**Fire Prevention and Protection
Plan**

Palmer Solar Project and Williams
Creek Substation Project

El Paso County, CO

June 2018

3.3 *Maintenance Schedule*

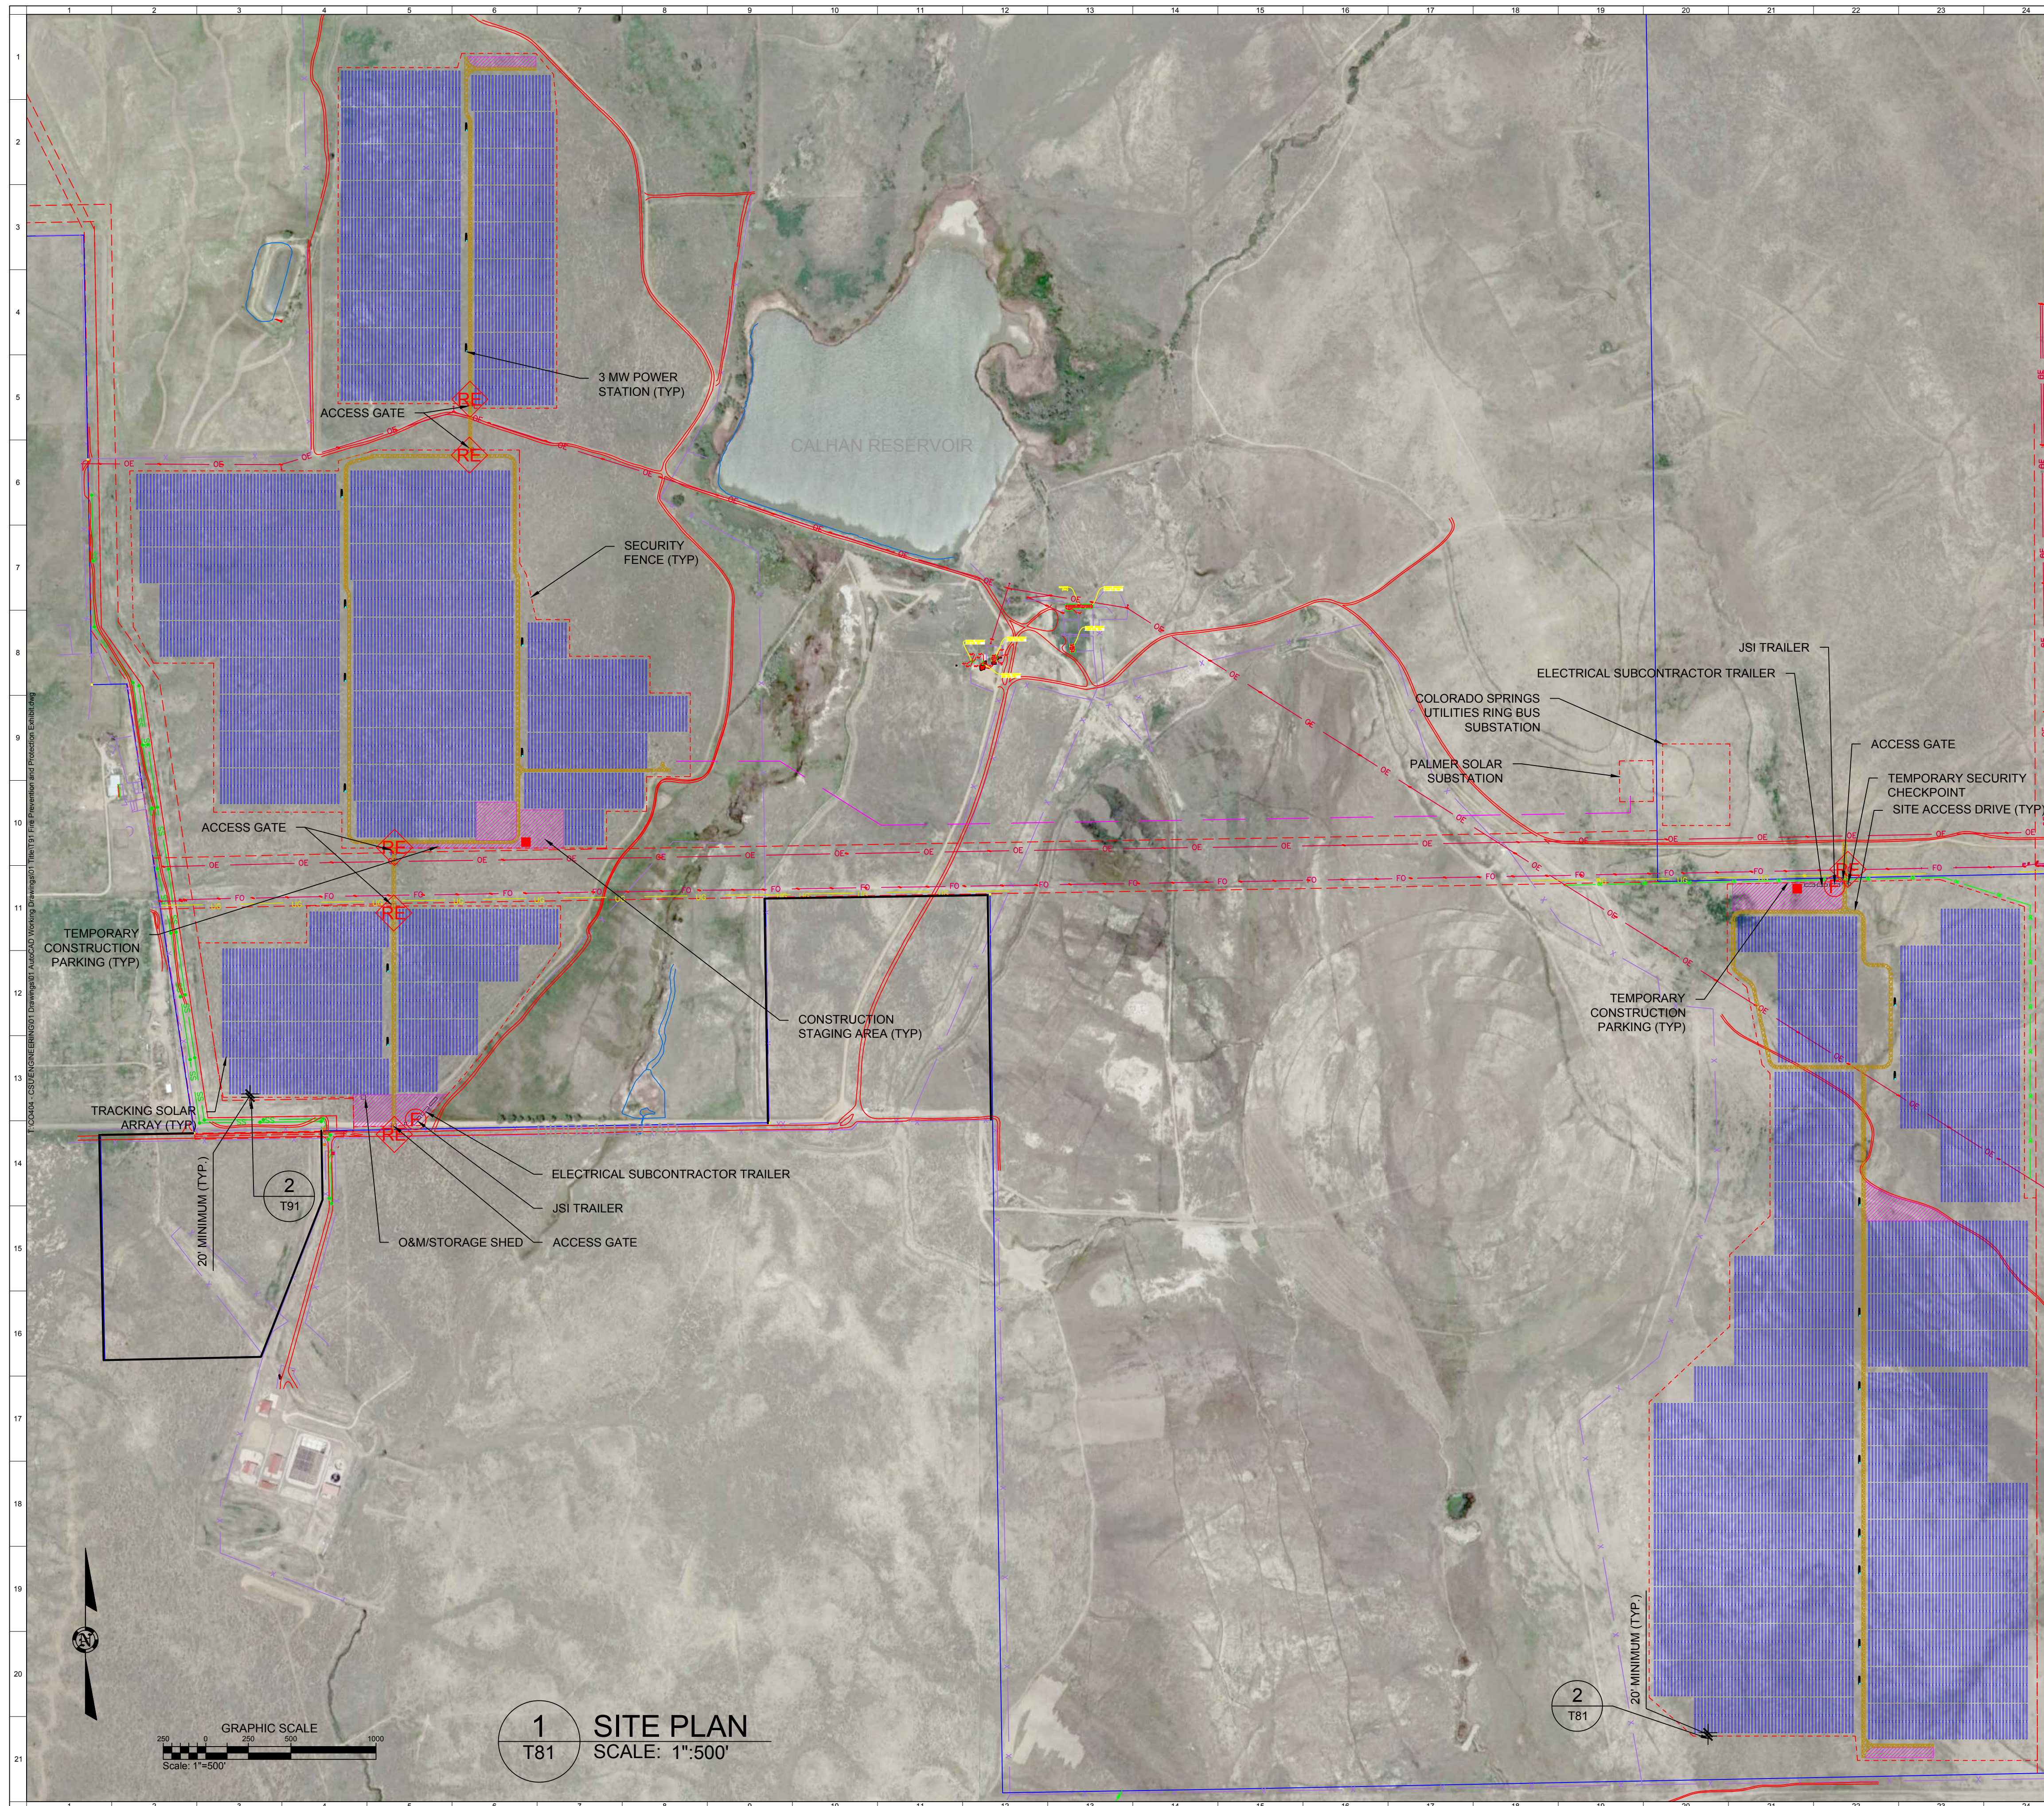
this contradicts the sentence above-clarify

Specify a max height. You may need to mow more frequently
